ENG-PUDSP21005-R3-PDR.pdf Markup Summary

WATERBURY FILING 1 & 2
EXISTING MDDP DRAINAGE MAP 1
OFFSITE MAP

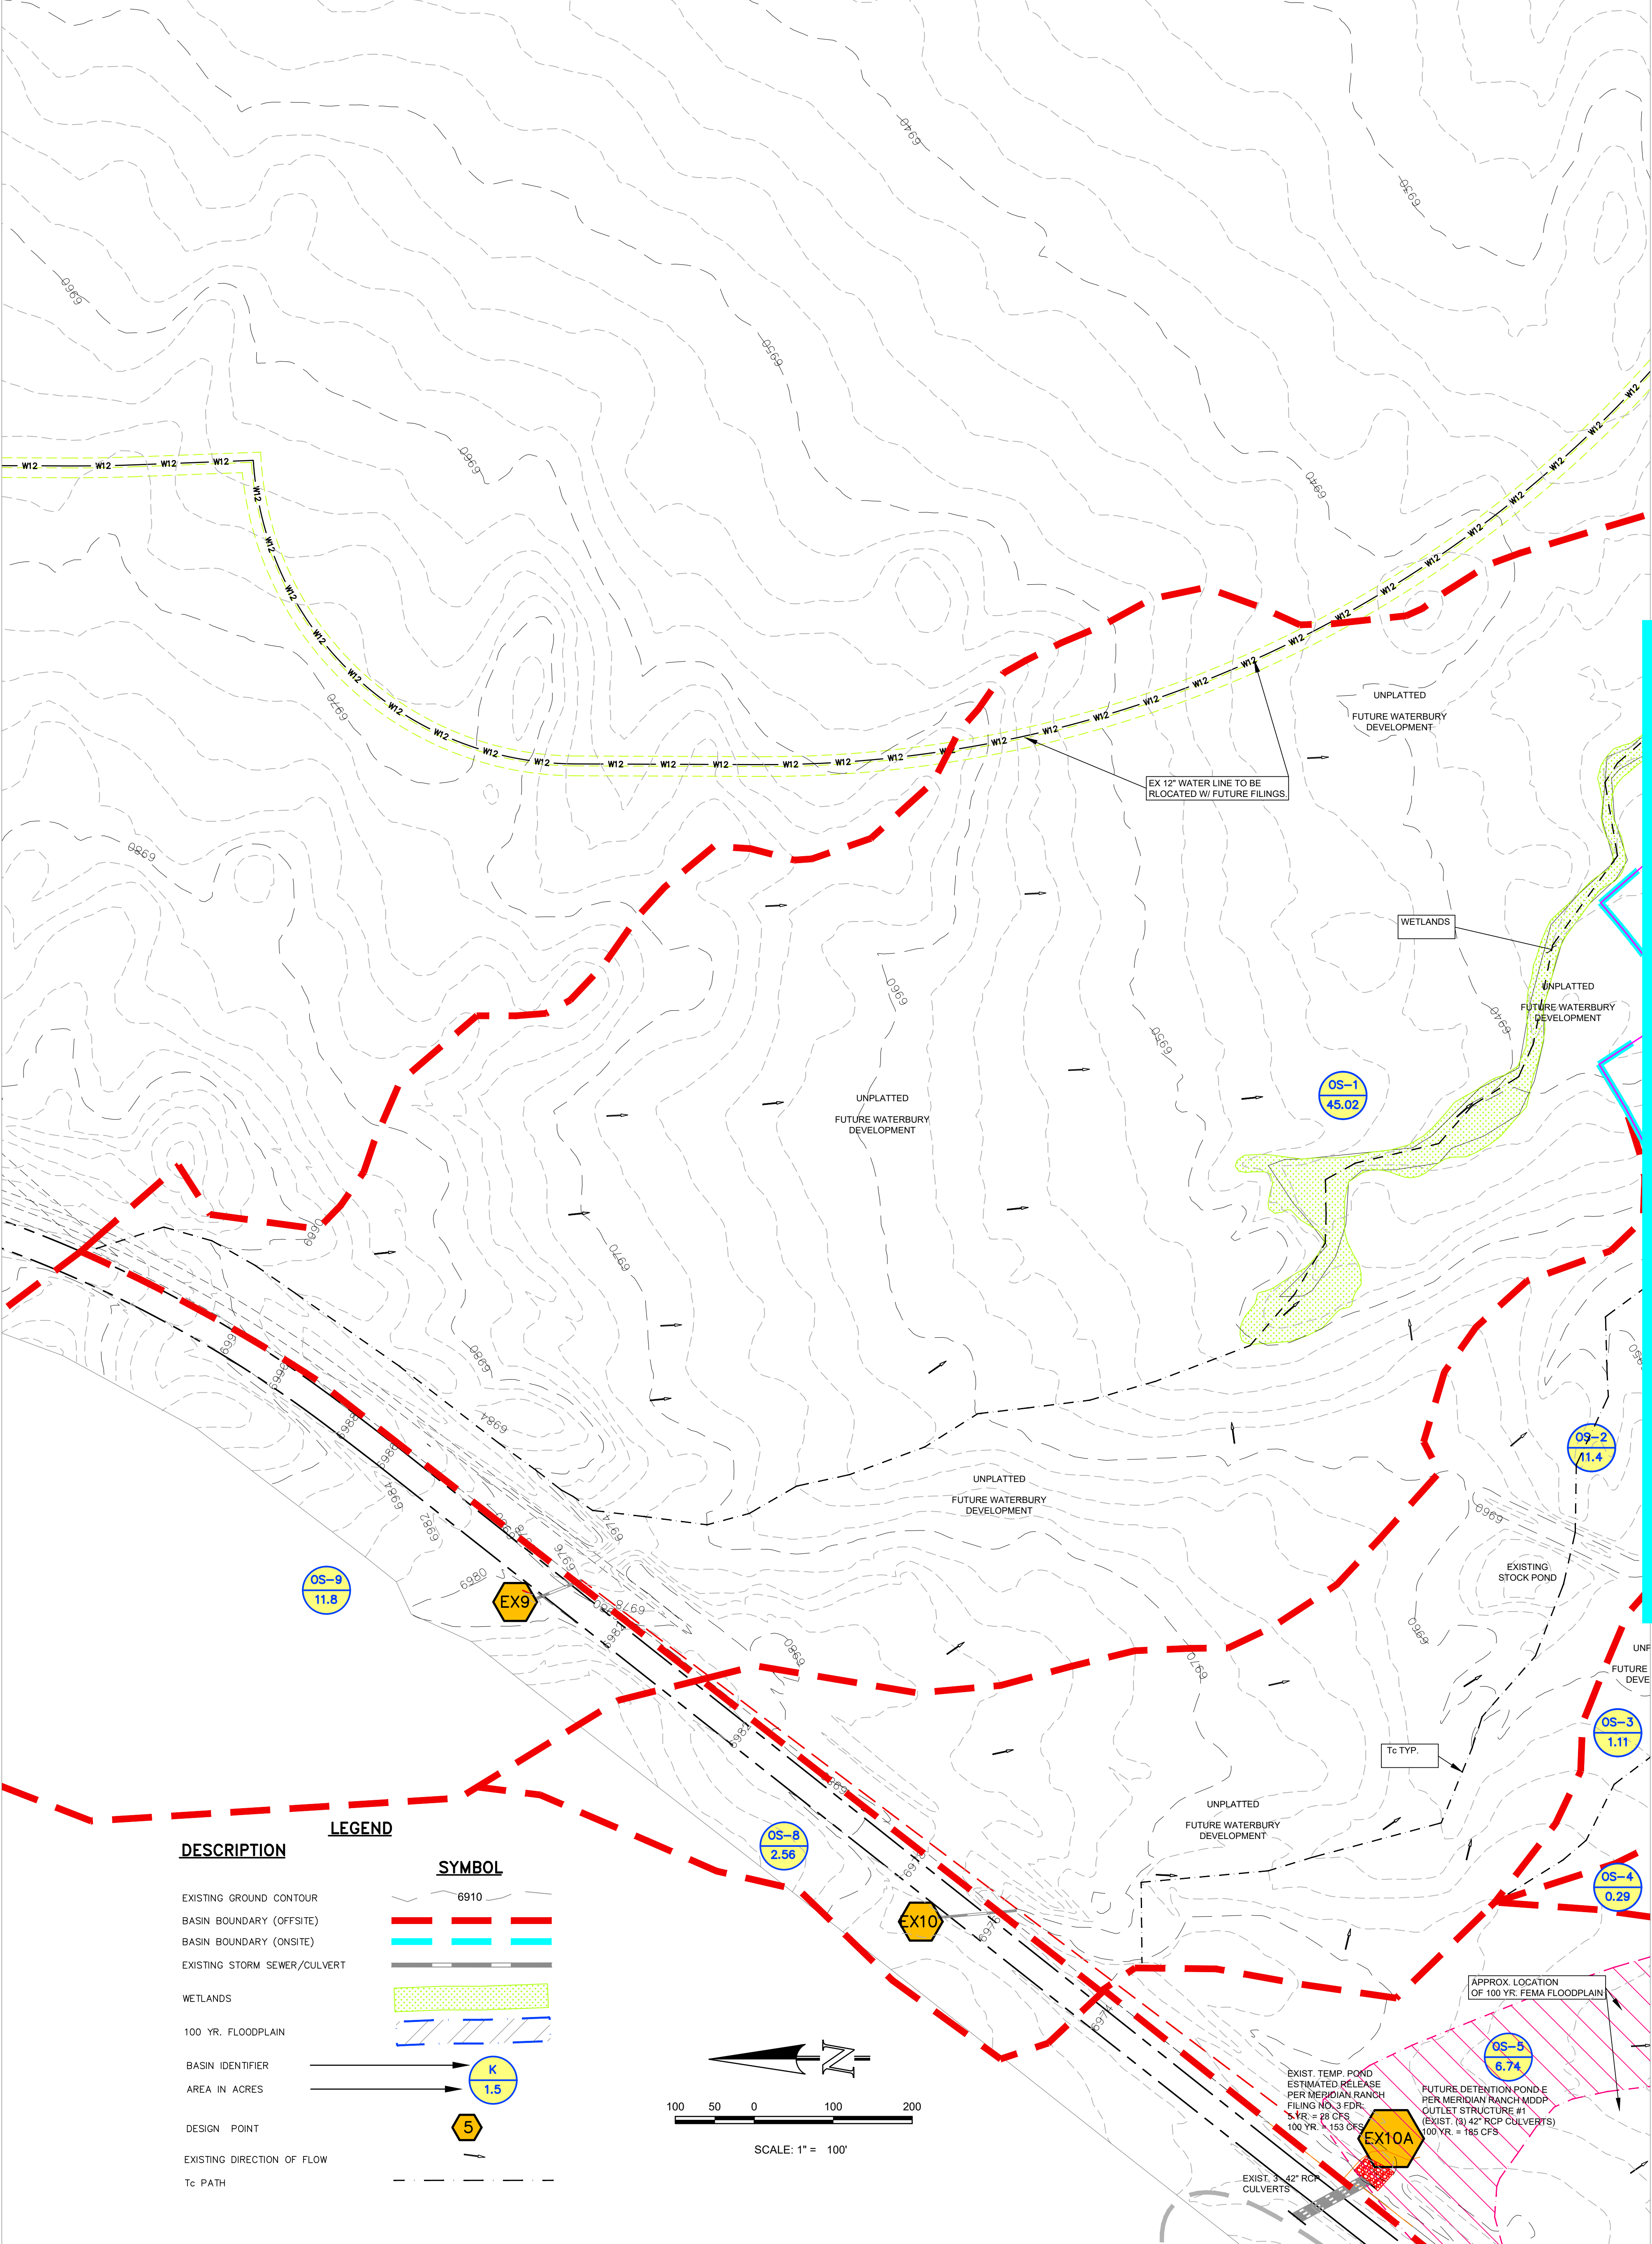
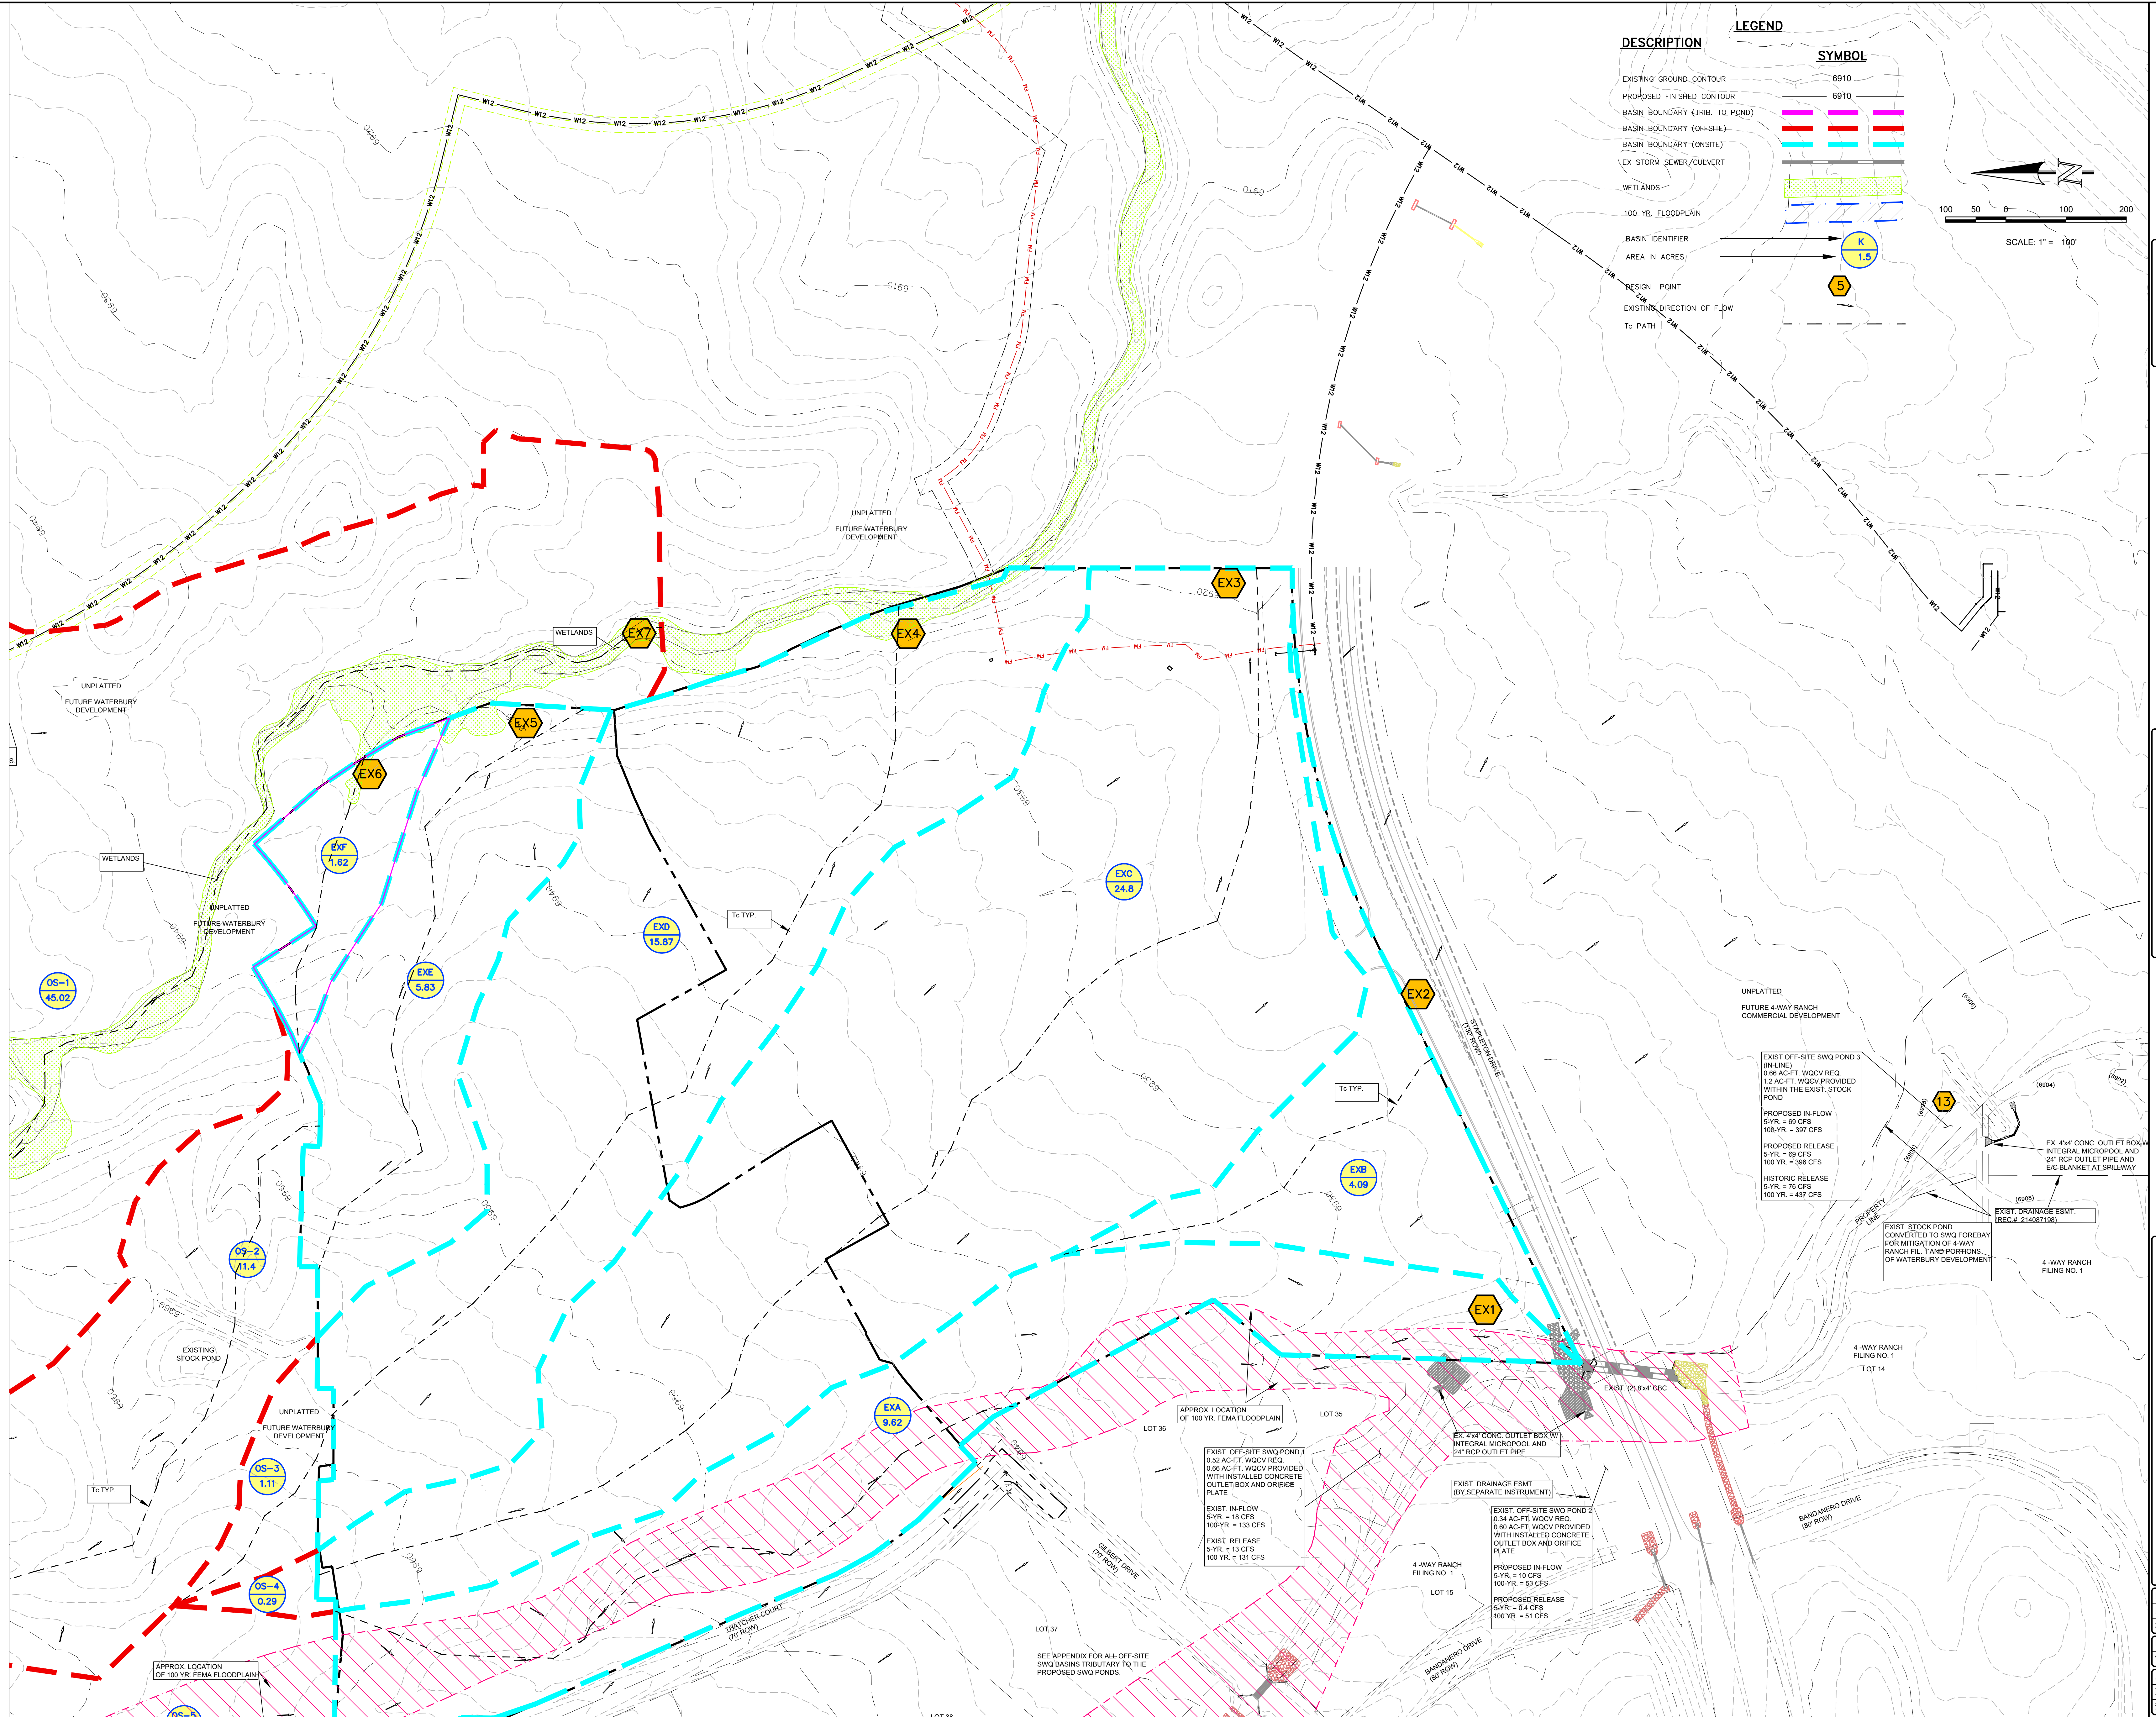
Missing Basin OS-9 in table & hydrology spreadsheet

Missing Design Points EX10, 9 & 13
